SUBJECT: LCU/Pat Deneen - Professional Surveying Services to Complete Palomino Fields Plat Div. IV in a portion of Section 27, Township 18 North, Range 28 East, W.M., Kittitas County, Washington

Reference is hereby made to your review comments regarding Palomino Field Plat – Div. IV, LPF-200000014 dated December 08, 2020:

TO: Community Development Services
FROM: Public Works Planning Review Team
DATE: December 8, 2020
SUBJECT: Palomino Fields Plat Division 4

TO: All Staff
FROM: Justin Turnbull, County Surveyor 
DATE: December 7, 2020
SUBJECT: Second County Survey Review of Final Plat LPF-20-000014 (Palomino IV)

Surveyed by LMH	Scale 1" = 100'
Drawn by Tml/FCS	Sheet 2 of 6
Checked by FCS	Project No. 18146

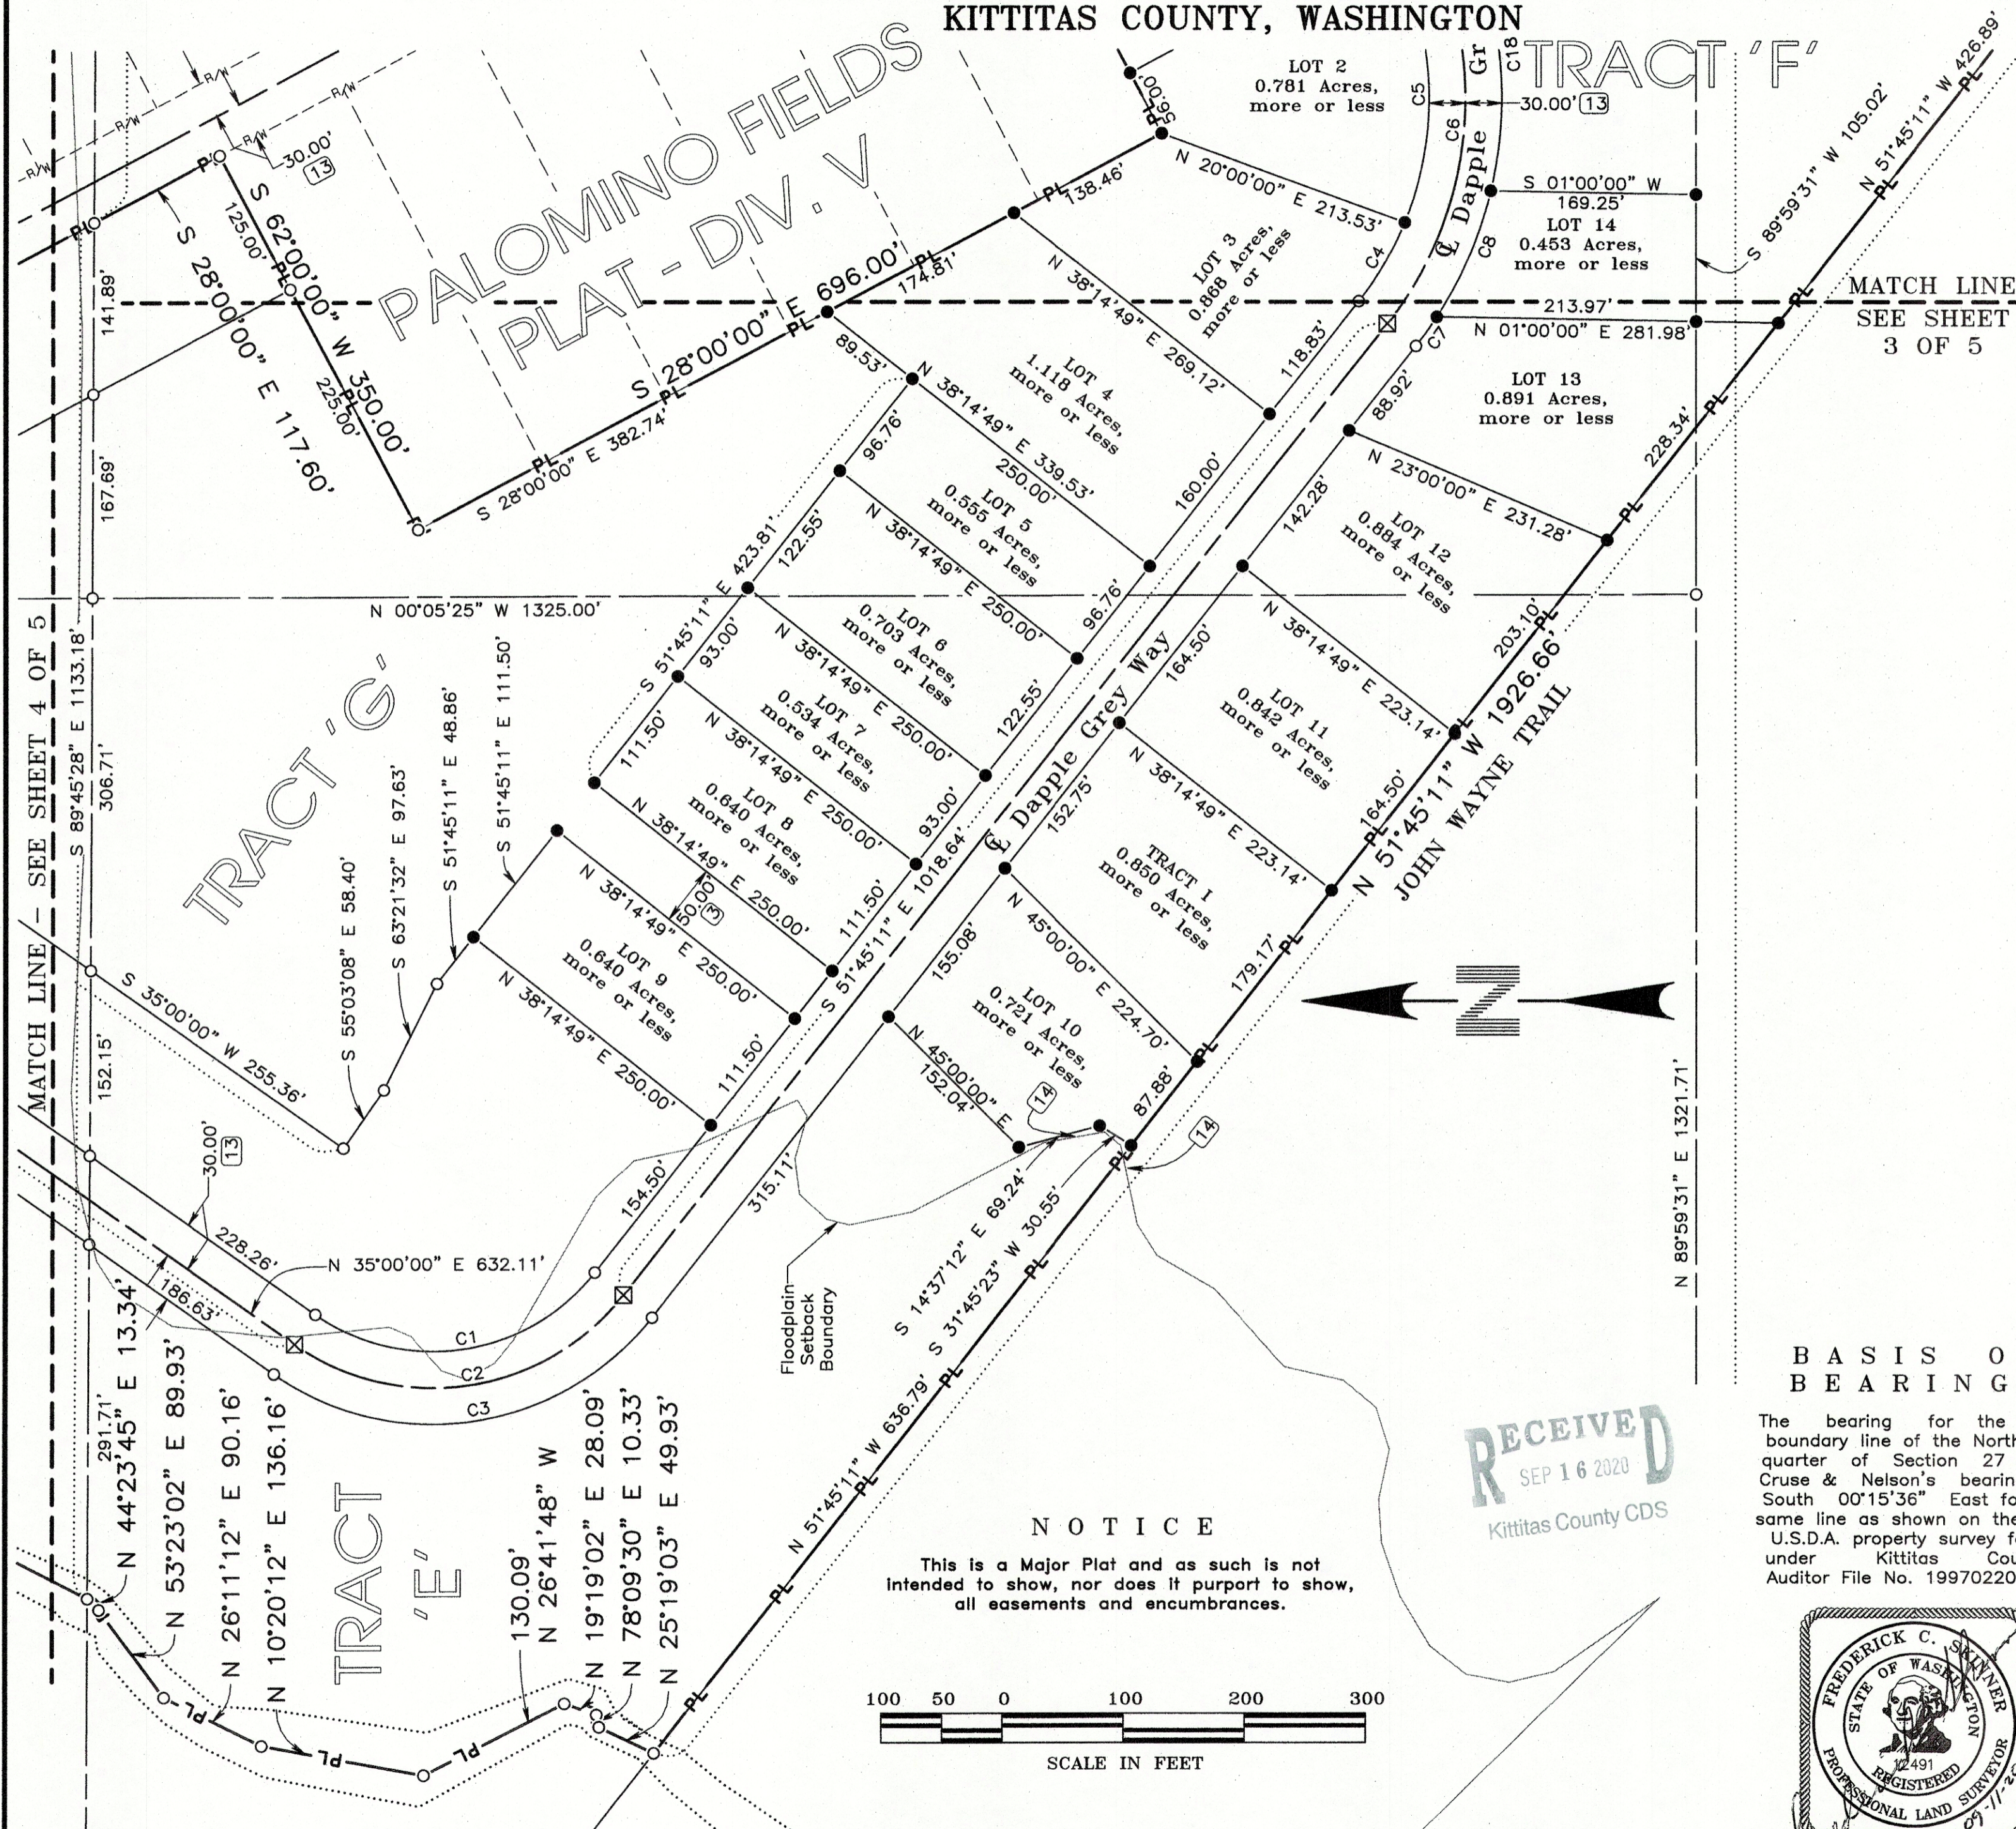
- a. Northernmost line of Tract F, shown as 146.15 feet in length, and appearing on sheet 3
- b. Easternmost line of Tract F, shown as 482.88 feet in length, appearing on sheet 3
- c. Curve on East boundary of Tract H, shown as C17 on sheet 4
- d. Curve of the East boundary of Tract e, shown as C3 on sheet 2

1. Note 13 is shown as reference to existing right of ways. Note 13 calls out "for emergency purposes" and is likely not relevant for primary access roads. This appears on multiple pages
2. Tract 'H' should be labeled

As you may recall, the concept was changed from a road system contained within Division IV from a public road system to a private road system. In doing so, we designated the road area as tracts and split the original 'Tract F' into three more tracts, one of which was originally an easement for the emergency ingress/egress road, making it a tract for easier clarification.

LCU, INC.	
Surveyed by LMH	Scale 1" = 100'
Drawn by Tml/FCS	Sheet 3 of 6
Checked by FCS	Project No. 18146

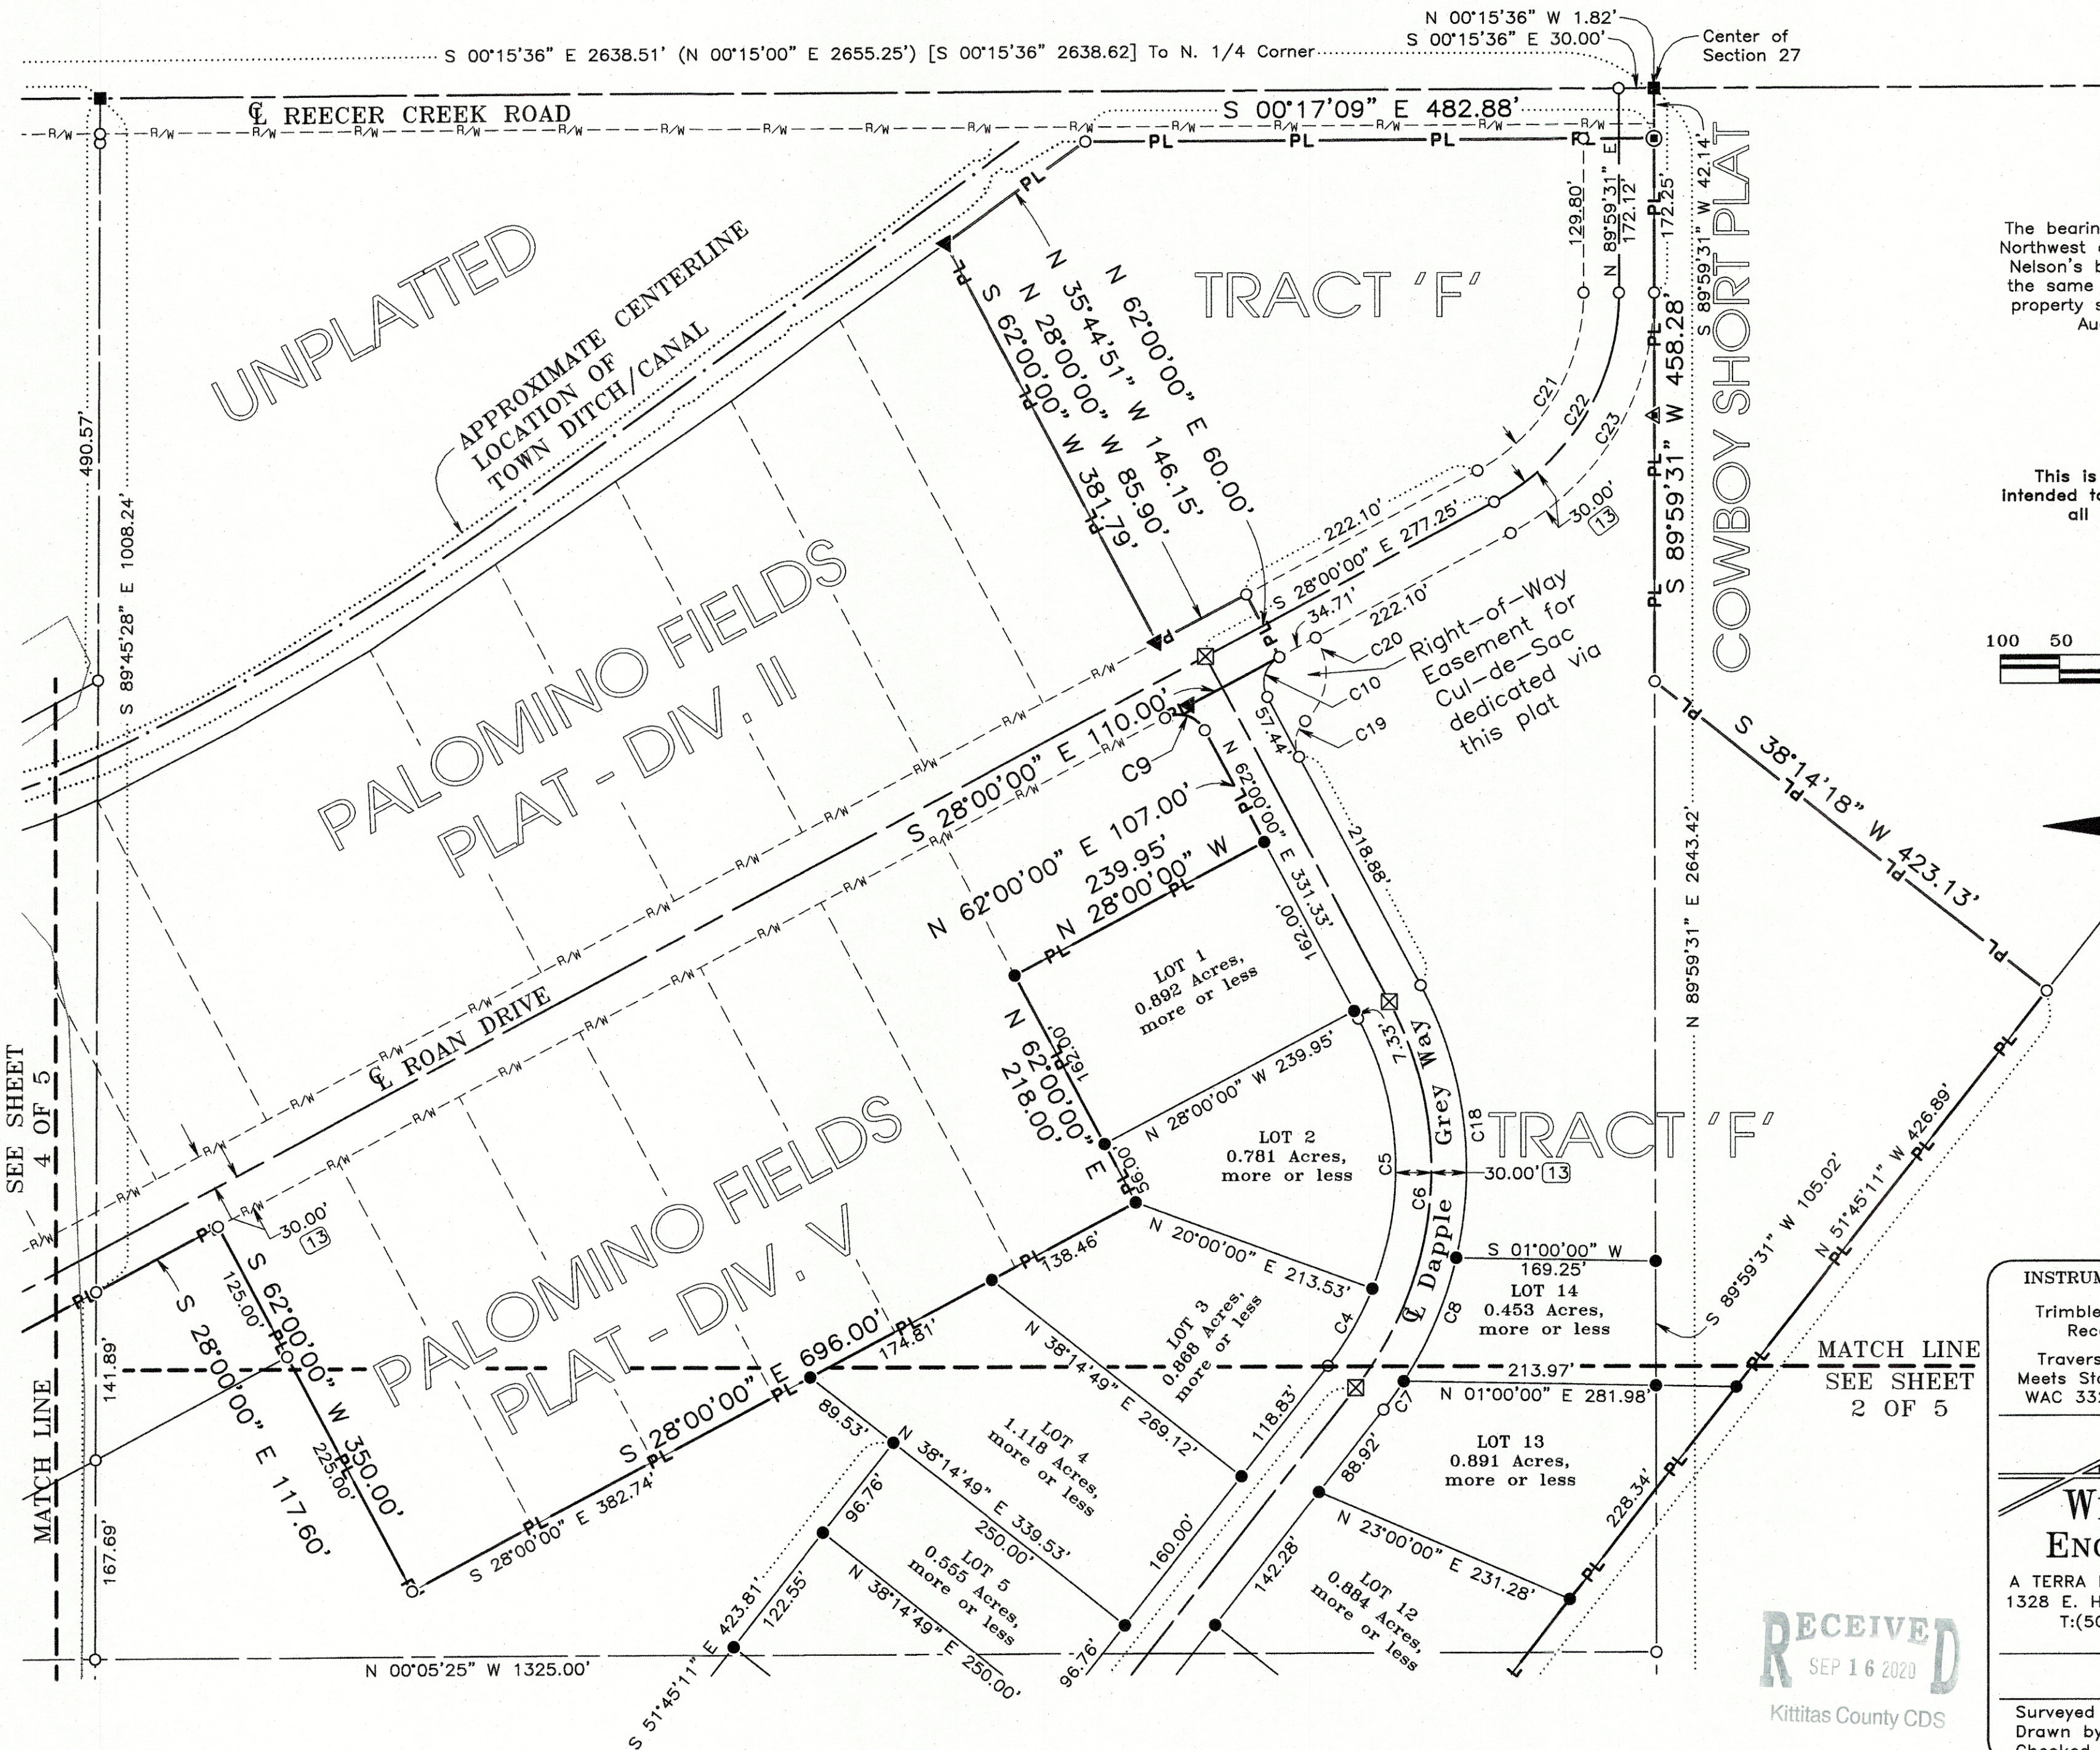
1. There is some confusion regarding the cul-de-sac area. WPE has identified this as a Right-of-Way easement. Please show this as right of way dedicated, and remove the included area from the total area of Tract F. Please also include the portion of the right of way on the East side of Road drive, as shown on Palomino III and V.

**ICU, INC.**  
Surveyed by: LMH Scale 1" = 300'  
Checked by: rml/FSS Sheet 1 of 6  
FSS Project No. 18146

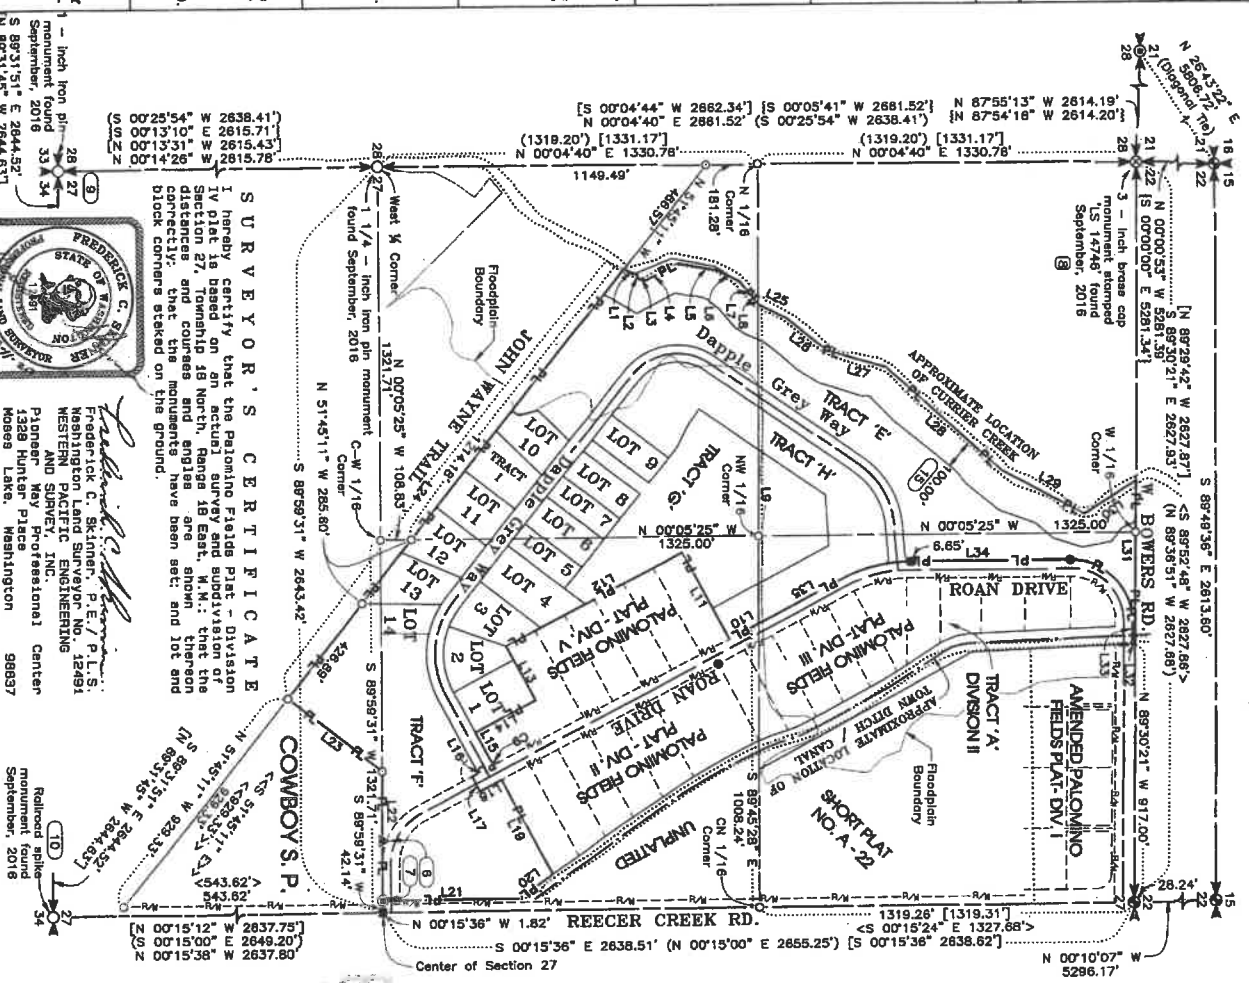
1. There is a dimension North of the intersection of Roan Drive and Dapple Grey Way, being 6.65' in length. This would be better suited to appear on sheet 4.
2. The 100' flood setback is shown as note 15. There is no note 15 of Sheet 5.
3. There is an existing building near Tract I. Please show this building and dimension to boundary lines to ensure it meets setback requirements. Typically this would be done as part of the preliminary plat, But I have never performed a formal review of a preliminary plat for this project.

The existing building mentioned as a review comment under Sheet 1, Item 3, has been removed.
